Ref: 6/2021/2816/HOUSE
Date: 11/01/2022

HISTORIC BUILDINGS AND CONSERVATION ADVICE

RE: 53 High Road, Essendon, Hatfield, AL9 6HS

The application is for extension of existing dropped kerb.

PROPOSED PLAN WITH EXTENDED
DROPPED KERB & BUSH REMOVAL

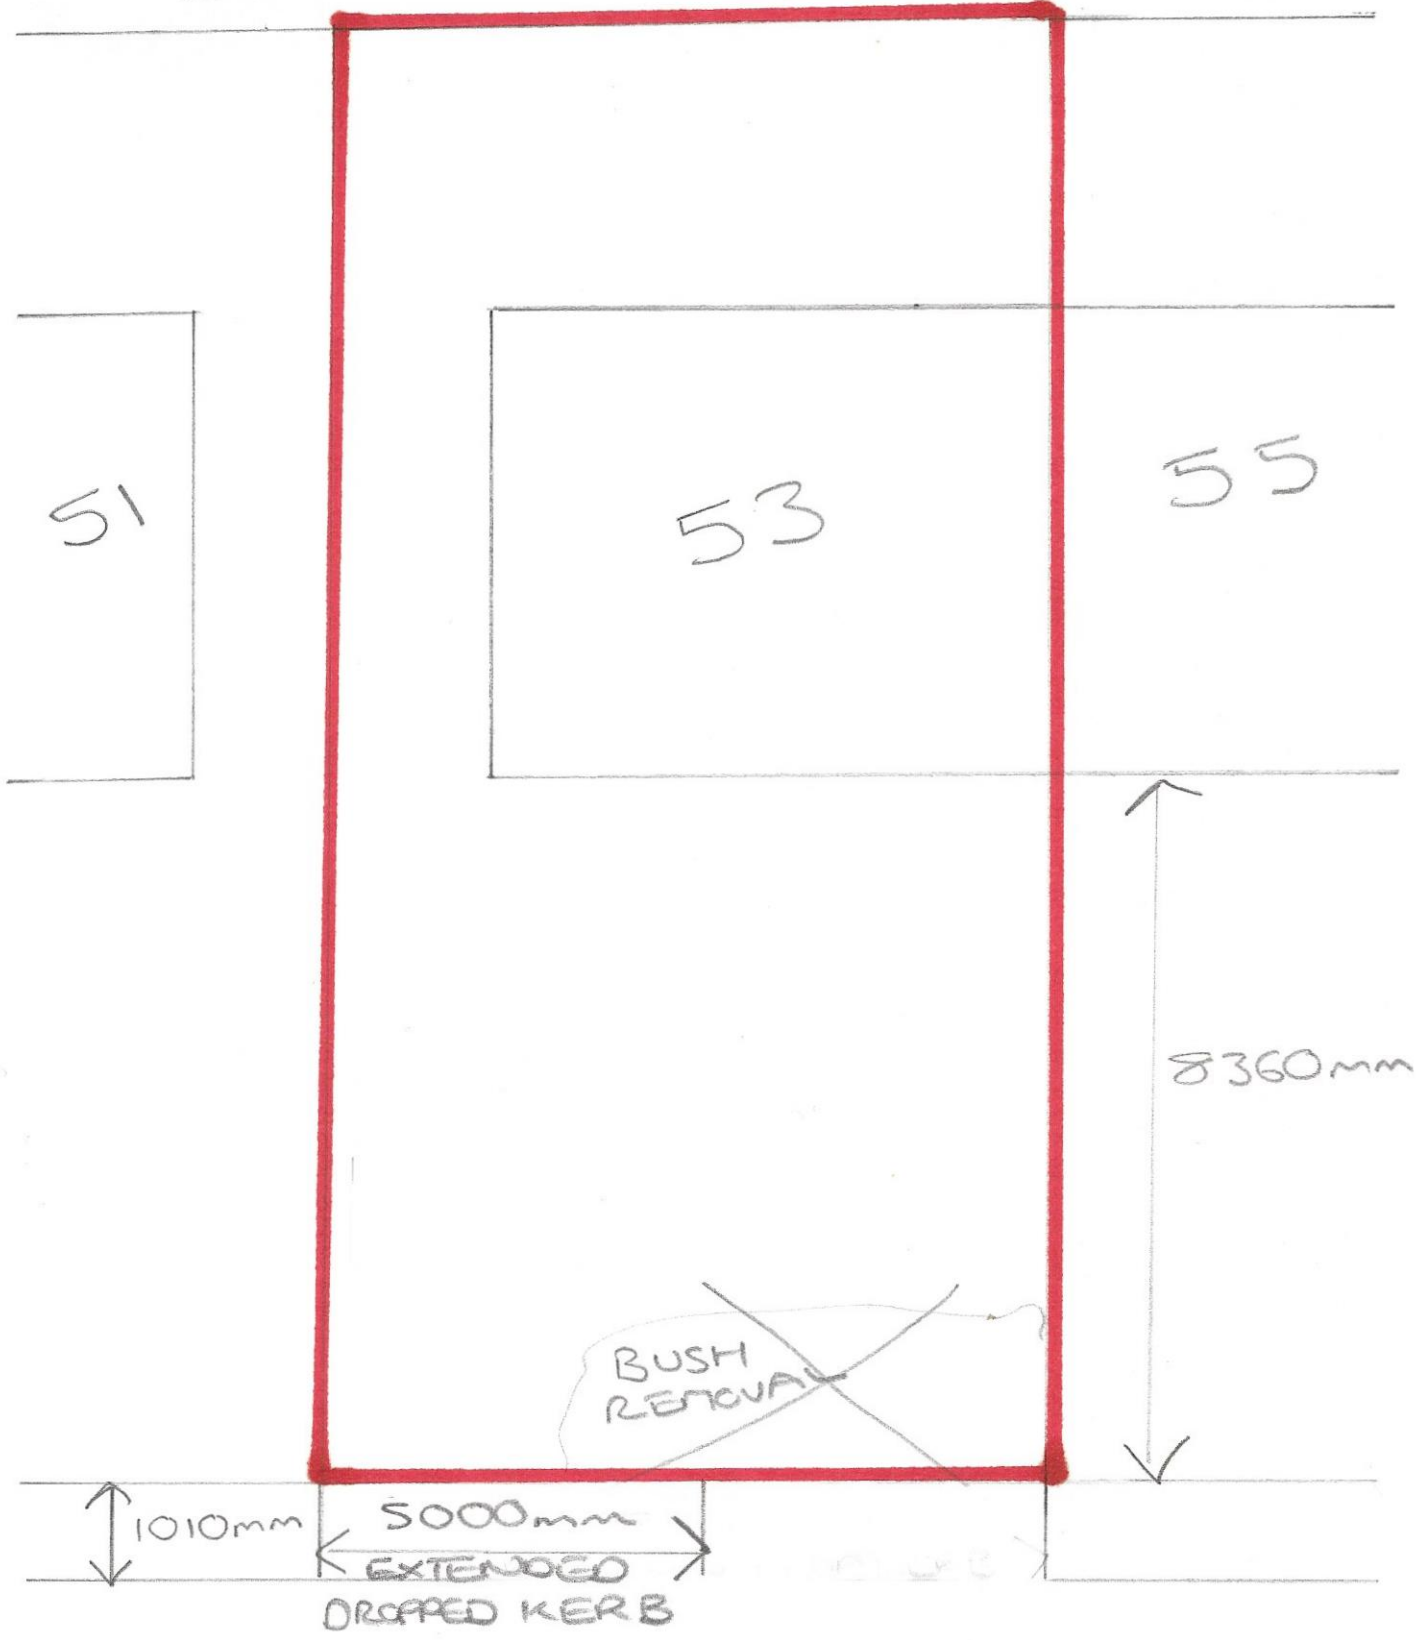
The scheme has been revised to amend the length of the proposed dropped kerb to 5 metres, however, it is still proposed to remove the front boundary hedge.

As noted previously, there is an objection to the loss of the hedge and the dwarf rendered wall along the front boundary. The revision has not addressed this concern. The loss of the hedge and boundary wall is considered to result in some 'less than substantial' harm to the significance of the Conservation Area and paragraph 202 of the NPPF should be applied. The proposal is not considered to preserve or enhance the character or appearance of the Conservation Area, as per Section 72 (1) of the Planning (Listed Buildings and Conservation Areas) Act 1990.
